NSW GOVERNMENT
Department of Planning

Major Project Request – Mixed use development (MP08_0244)

Lot A in DP 418891, Lot 11 in DP 713206, Lots 101, 102 and 103 in DP 1067930 and Lot 3 in DP 713505 – 23, 23A, 27 – 37 Lindfield Avenue and 11 Havilah Lane, Lindfield.

DRAWING TITLE:
SHADOW DIAGRAMS - JUNE

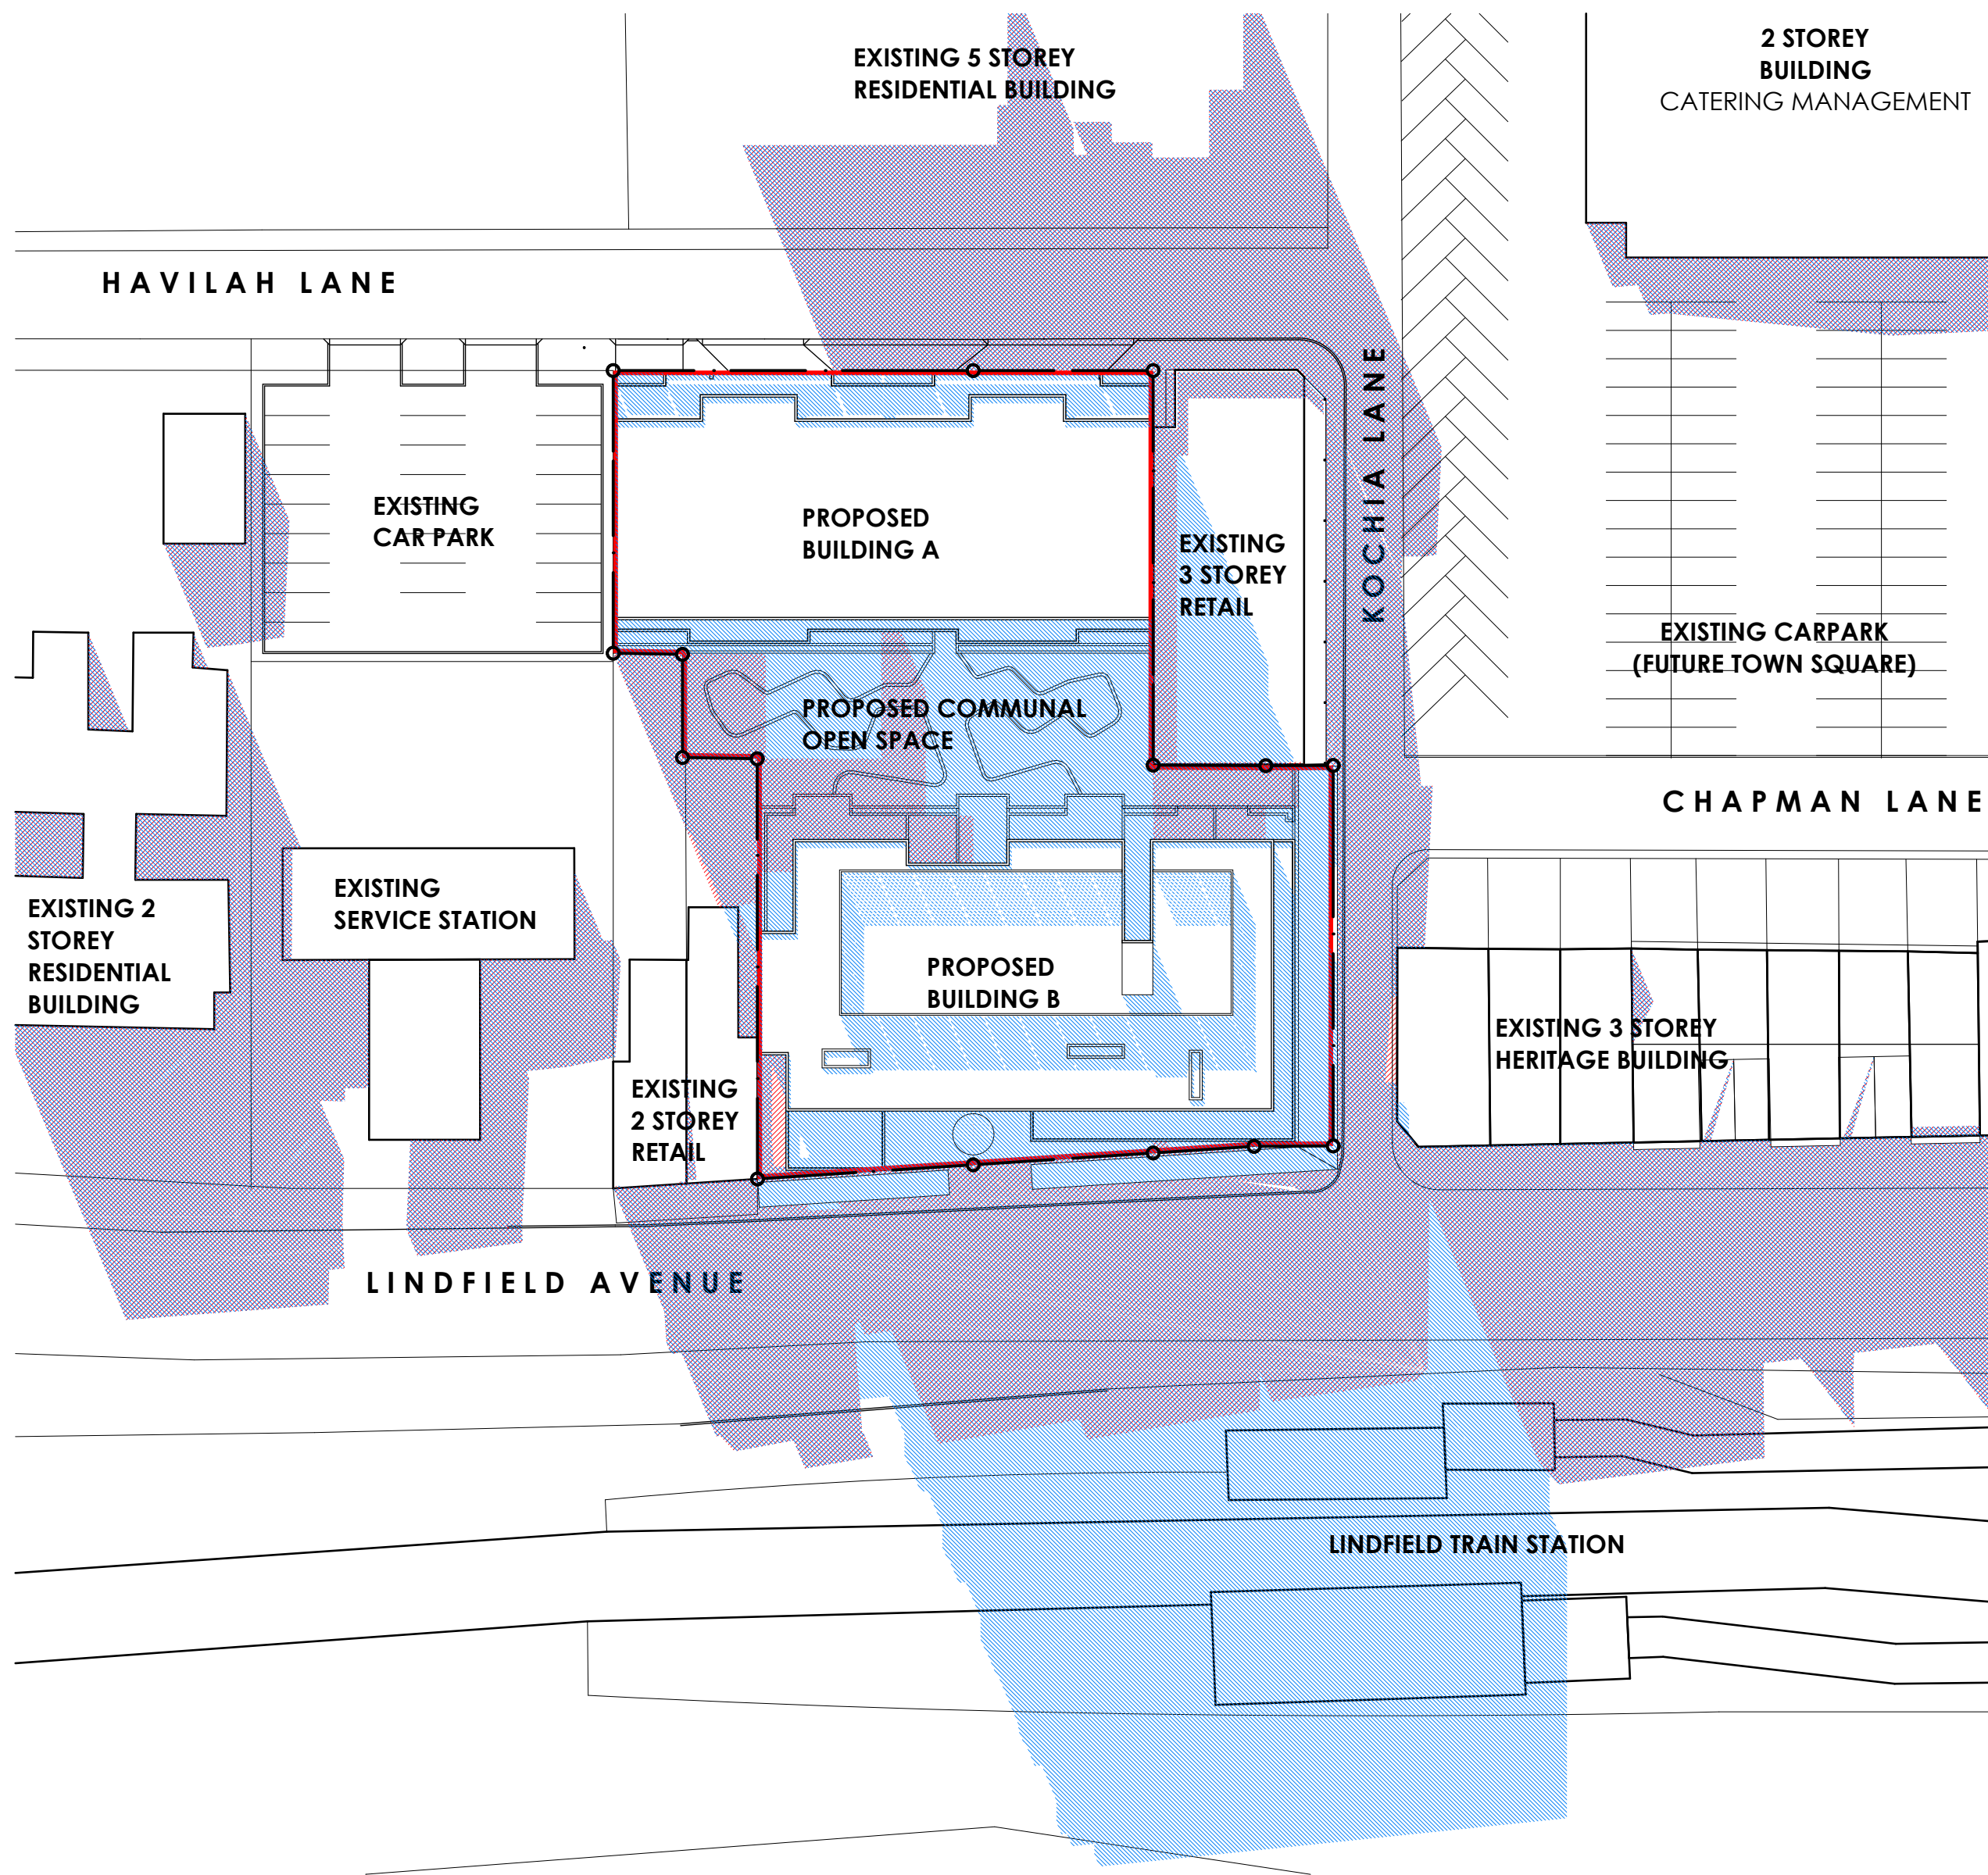
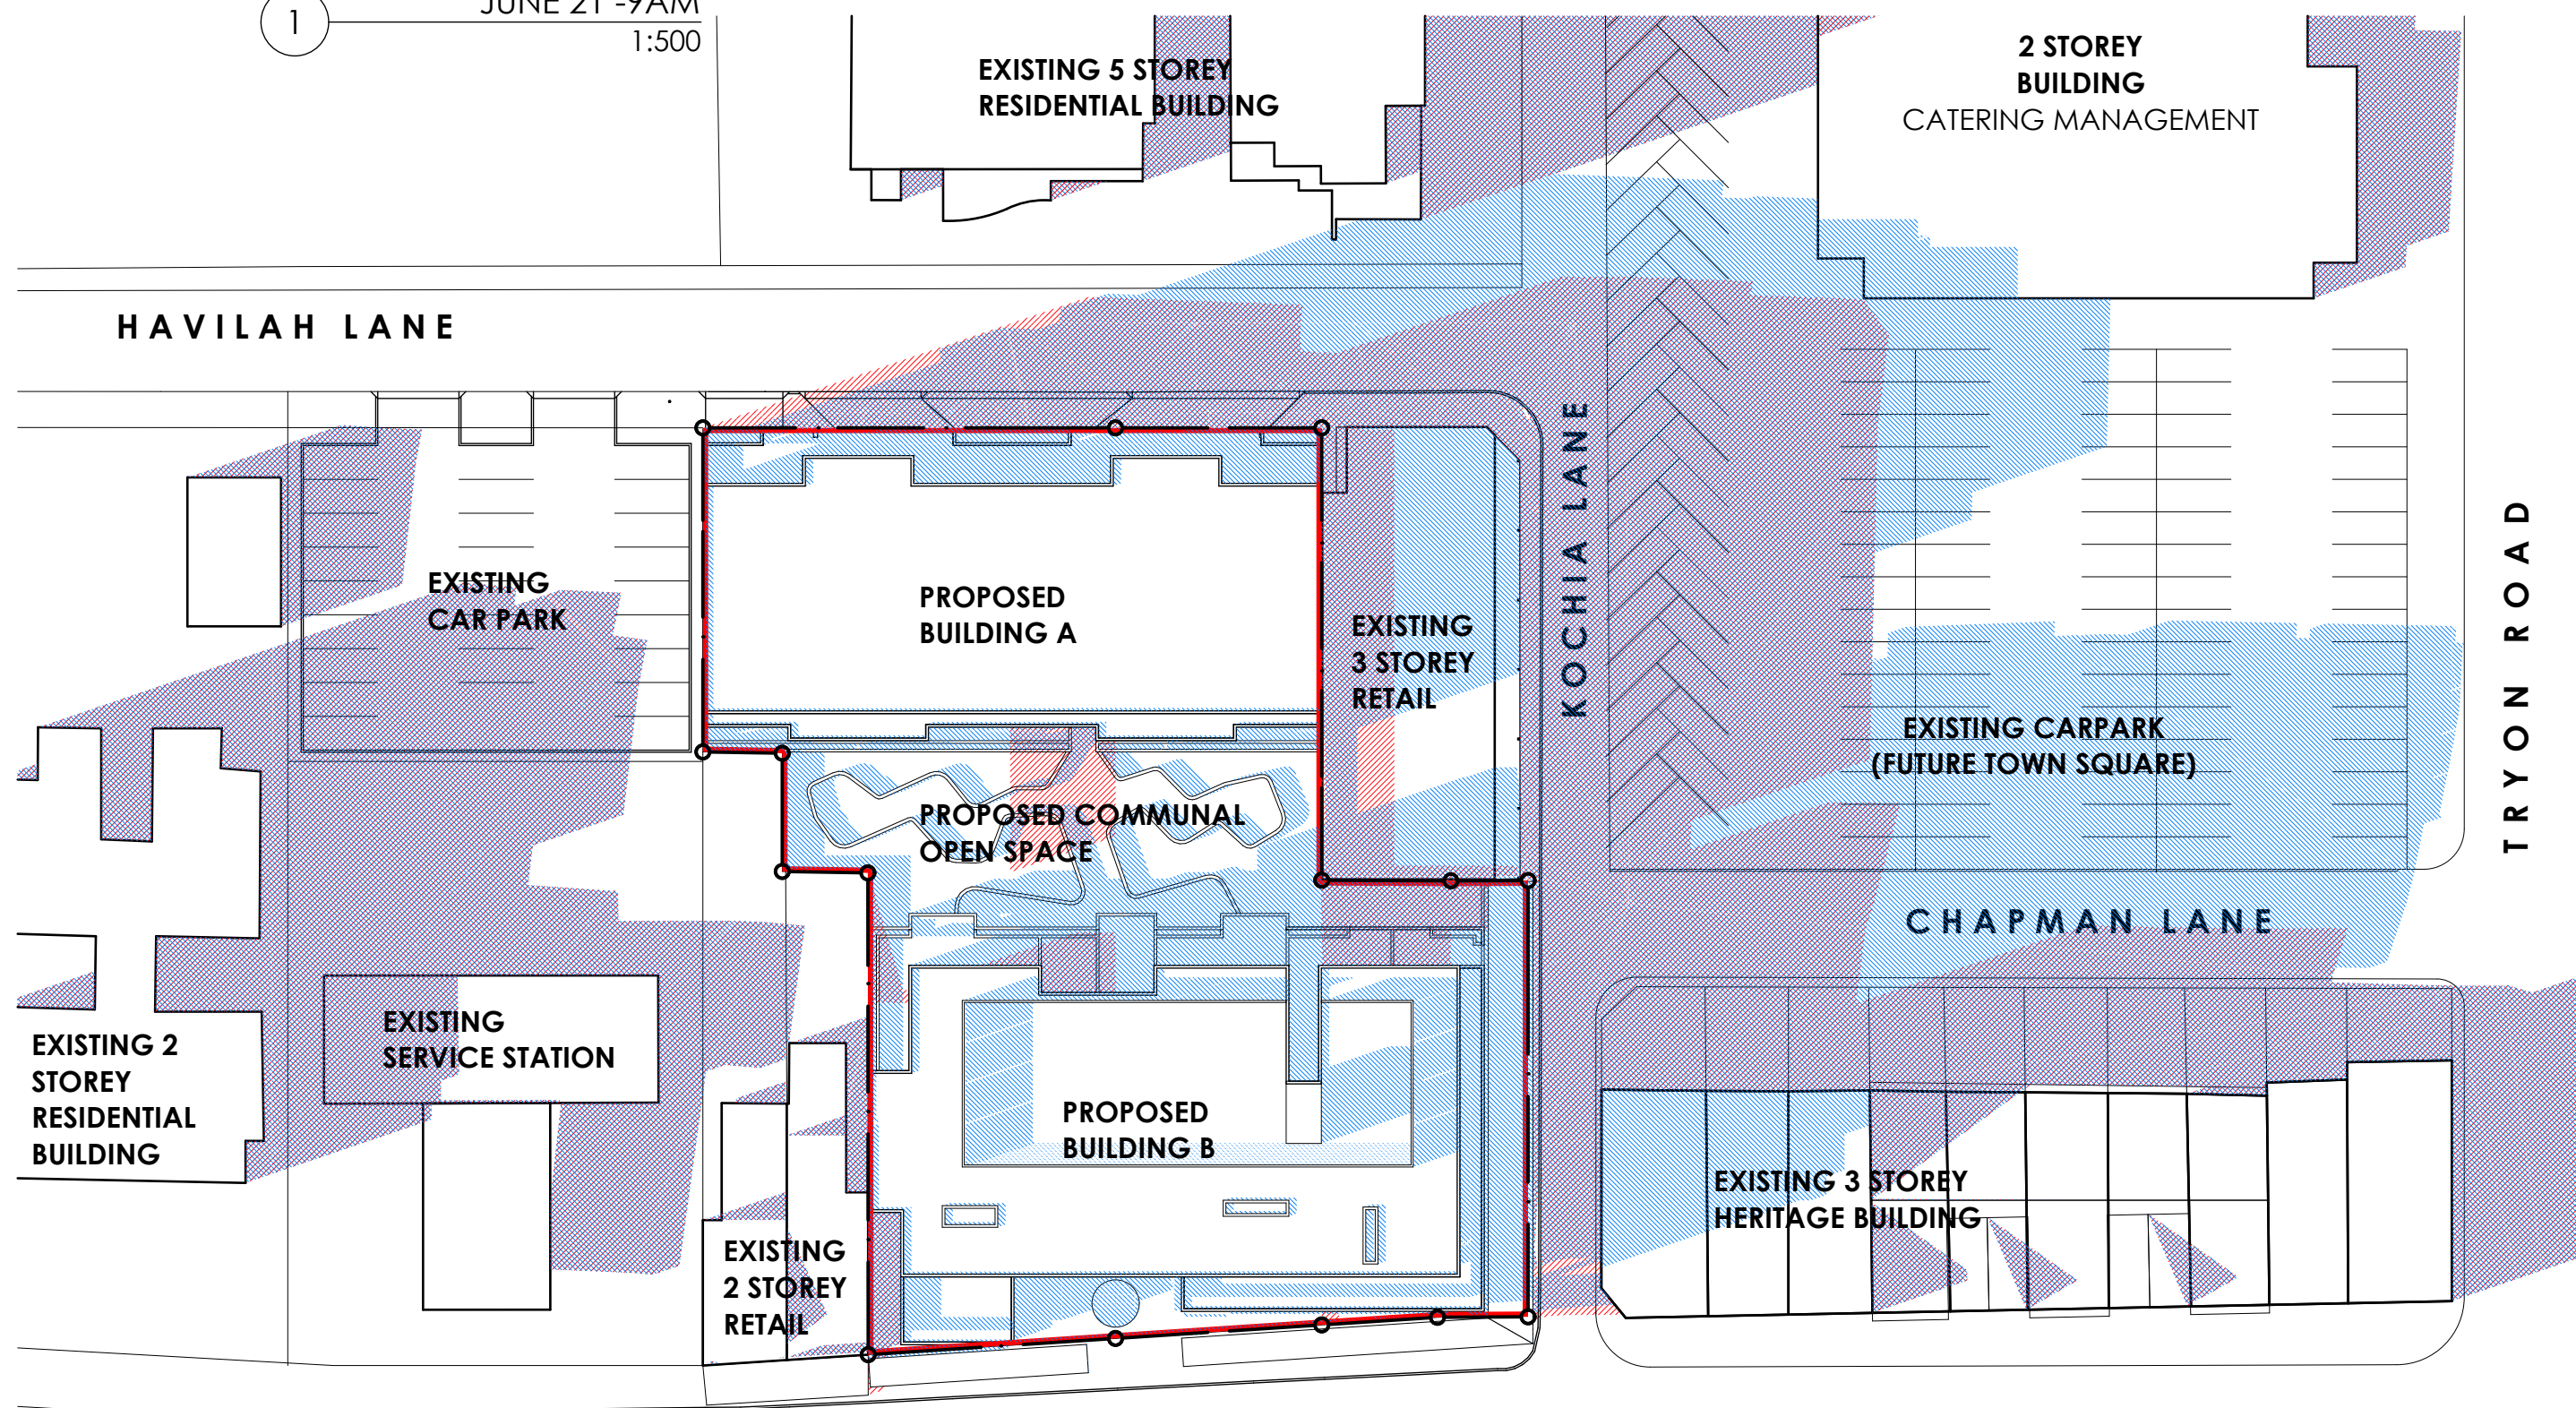
Careful consideration should also be given to the visual relationship between the existing residential development to the north-east (rear lane) and the heritage listed building to the south, along Lindfield Avenue. Particular care should also be given to the treatment of the loading dock area. The design of the private communal open space should ensure optimum levels of solar access are provided in accordance with the provisions of SEPP 65.
